**RE: VARIATION OF CONDITION APPLICATION REFERENCE PP-15150526;
FOR PLANNING APPROVAL 3/2026/0140; ROSE HILL FARM, WHALLEY OLD ROAD, BILLINGTON, BB7
9JF**

Application 3/2026/0140, for the proposed demolition of an existing dwelling and outbuilding, and replacement with one new self-build dwelling, outbuilding and garage was approved on 15th July 2026.

Proposed Site Plan - Ground Floor
Scale 1:200

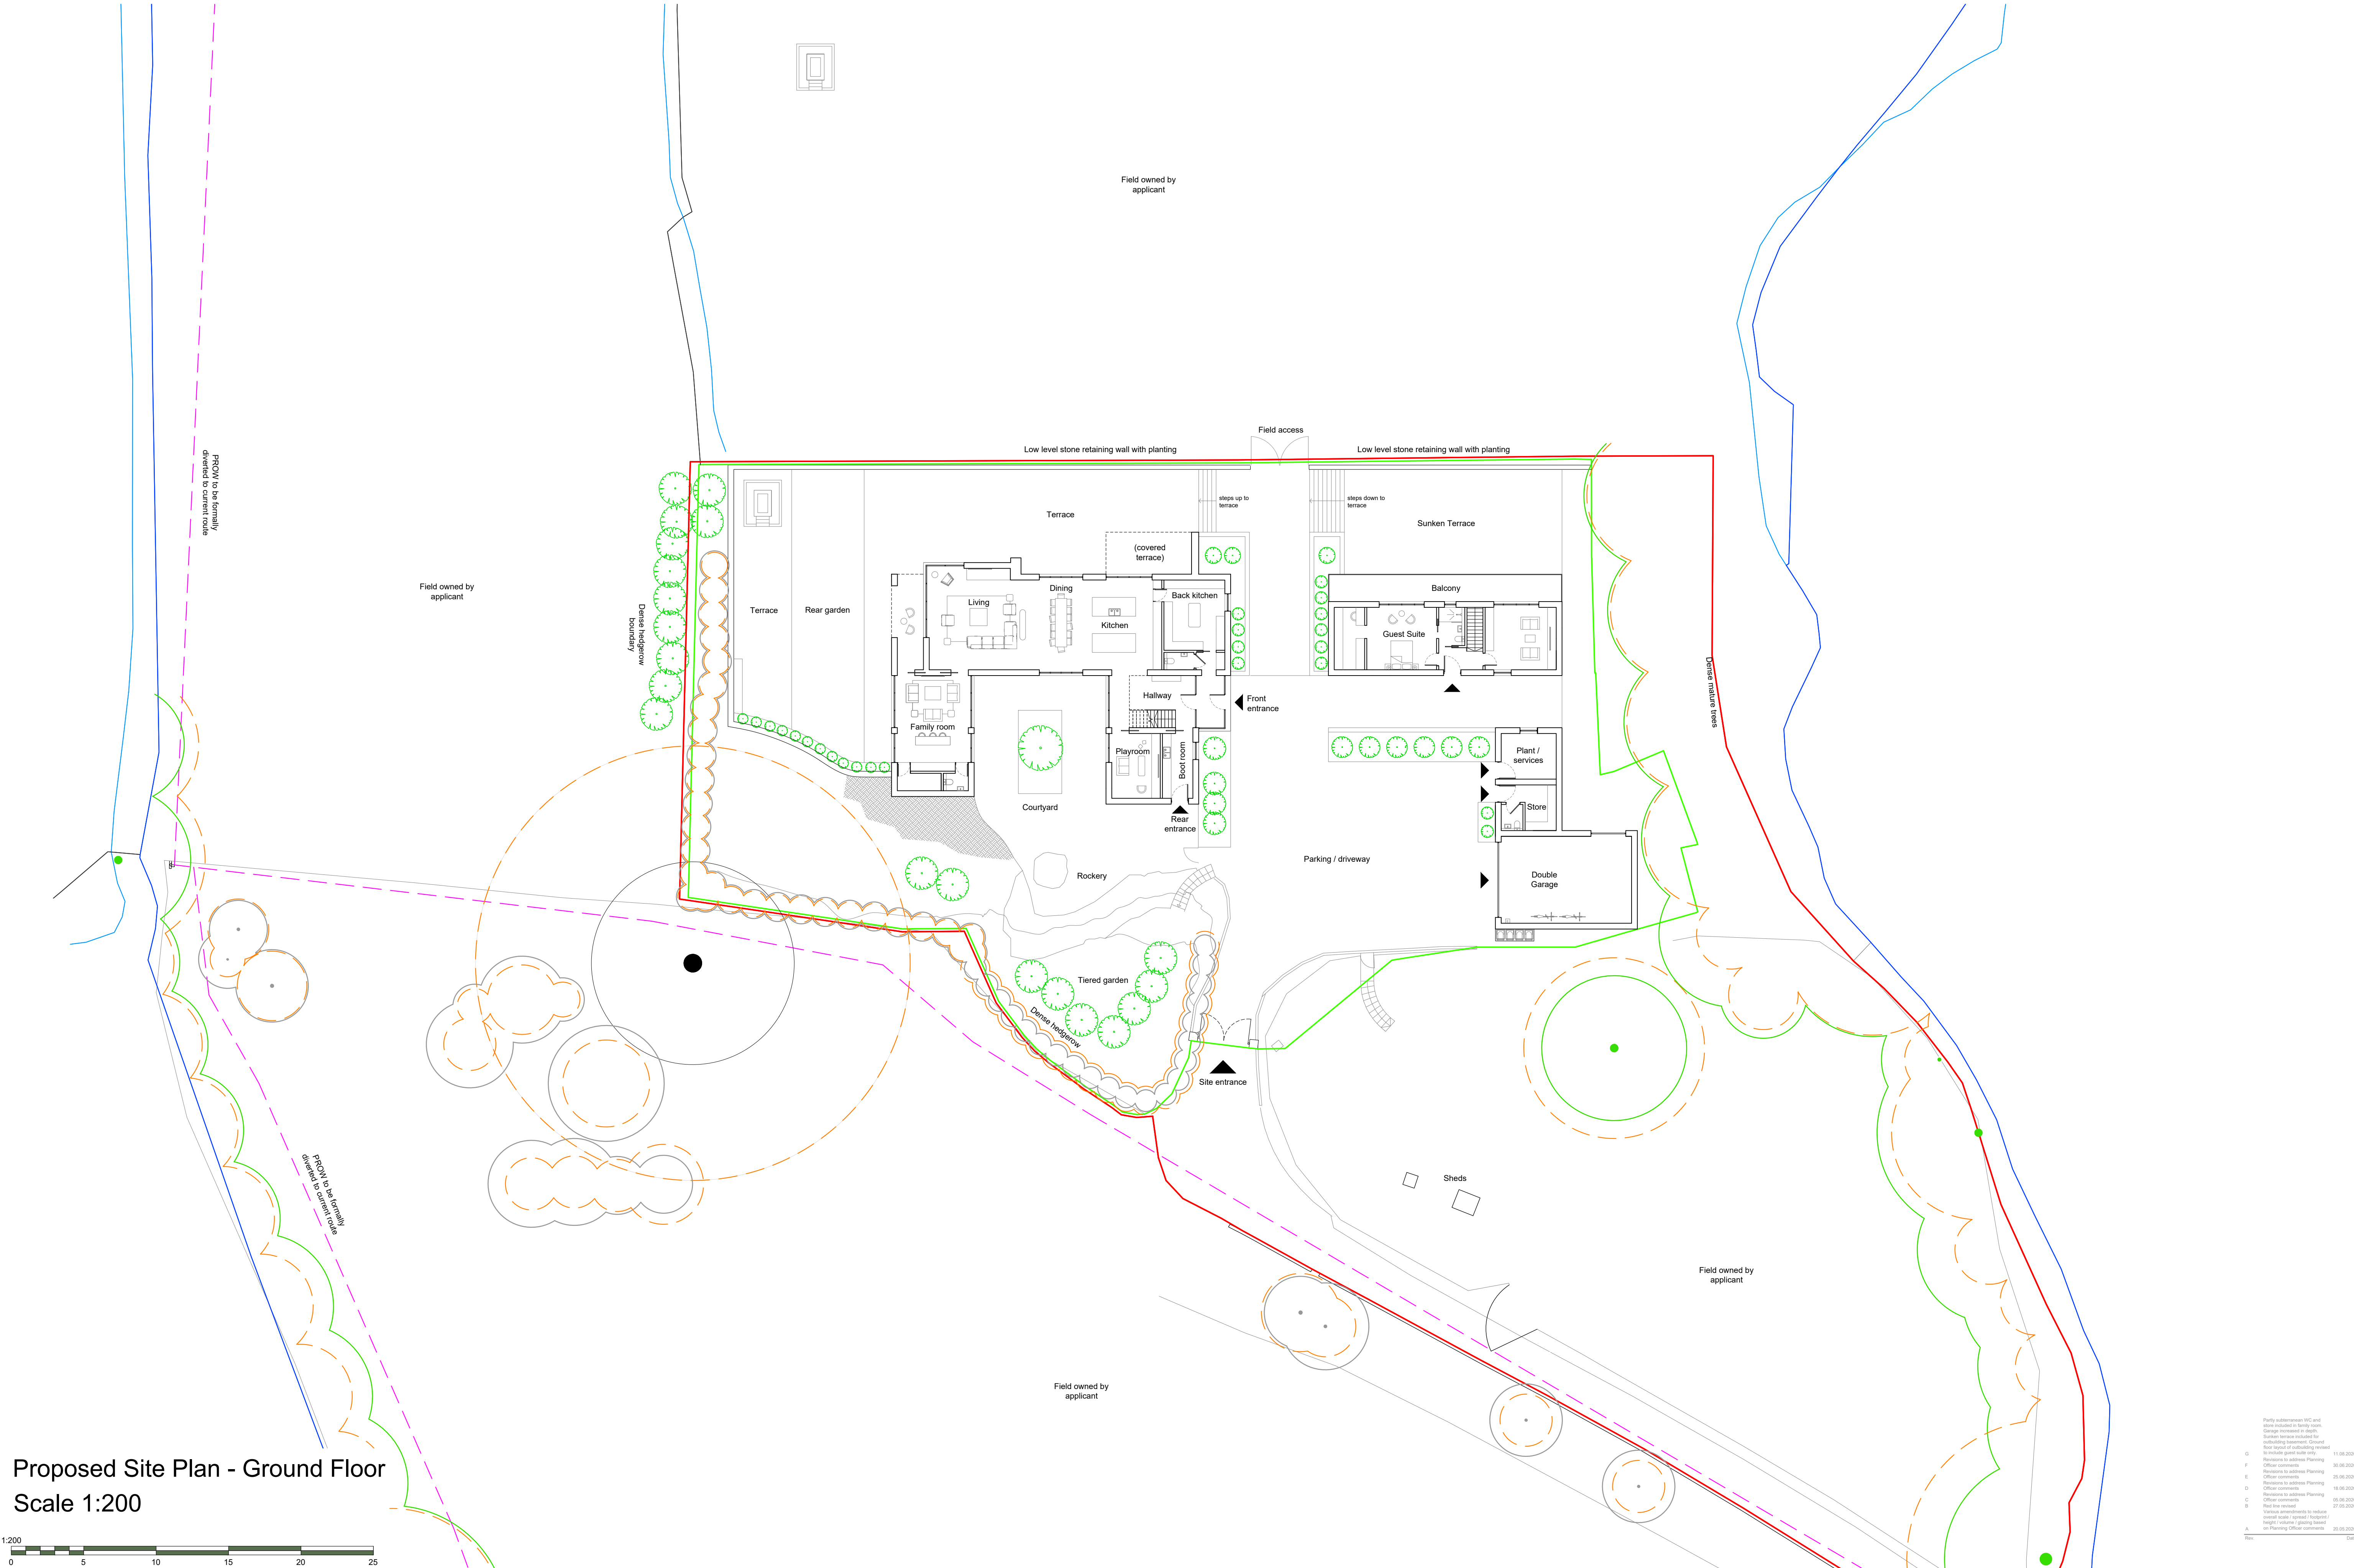
The proposed ground floor layout of the house reinstates the WC and store within the games room. However, to maintain the extant elevation, this element of the building is part-subterranean, hiding the WC and store within the existing gradient of the South garden. The proposed elevations therefore remain unchanged.

The size of the outbuilding was reduced in scale which resulted in a significant loss of accommodation to the guest suite and gym. A basement level has now been proposed below the outbuilding. By introducing a basement level, the scale of the approved outbuilding remains unchanged at ground floor level, whilst allowing the applicants to incorporate a larger guest suite and gym without impacting the volume or visual appearance of the outbuilding.

As the house accommodation was scaled down during the application period, the plant and service spaces within the house were omitted. As the house will be highly sustainable, including solar panels, battery storage and a sustainable heating and ventilation system, a plant and service space is still required and is therefore proposed within the basement level of the outbuilding.

reduced below the requested 30-40% to 23%. As the planning officer had no issues with the scale of the garage, and the applicants require space to store 2 cars and a ride-on-mower to maintain their land, the garage outbuilding has been increased in depth. By increasing the depth within an area of the site which is hidden from view, the applicants achieve their required accommodation without causing any visual impact.
